From: Janice Chapman
Sent: 02 April 2015 09:06
To: Nicola Spencer
Subject: FW: EG/14/15/HH - Two storey side extension at 33 Elm grove, Eastergate
Attachments: TaylorDraft3b010415.pdf

From: Paul Quantrill [mailto:paul@architectural.uk.com]
Sent: 01 April 2015 18:11
To: Janice Chapman
Subject: RE: EG/14/15/HH - Two storey side extension at 33 Elm grove, Eastergate

Location Plan

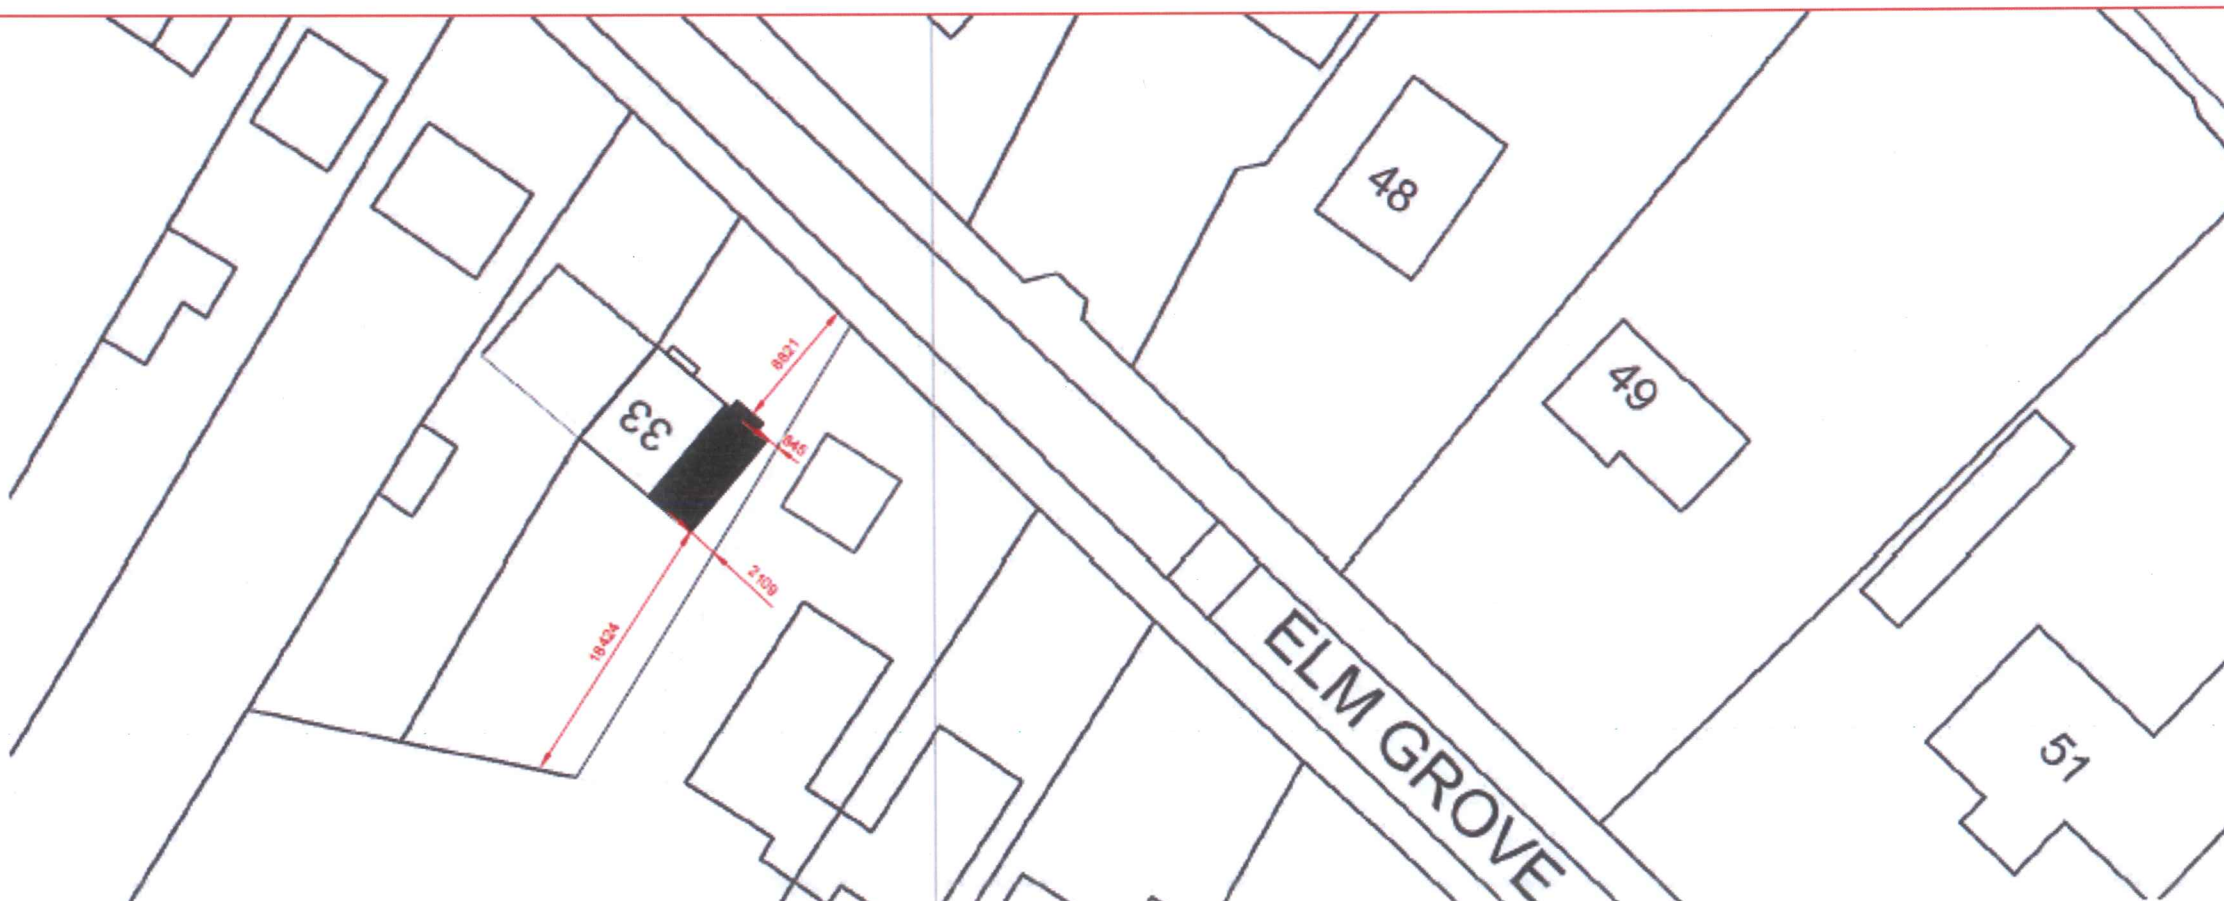
In view of the Parish Council objection the application which will be recommended for approval will have to go to the Development Control Committee Meeting on the 22nd April. Please can you submit an amended Block Plan as previously advised as the plans are shown at the Committee Meeting and at the present time the existing Block Plan is inaccurate.

I am the case officer dealing with the above application. From a site inspection it appears that the neighbouring property No 32 Elm Grove has been extended to the front with a detached garage to the front adjacent to the boundary with No 33. Please can you submit an amended Site and Block Plan to show this.

Please find attached the updated drawings with the revised block and location plan to show the neighbouring extensions and garage.
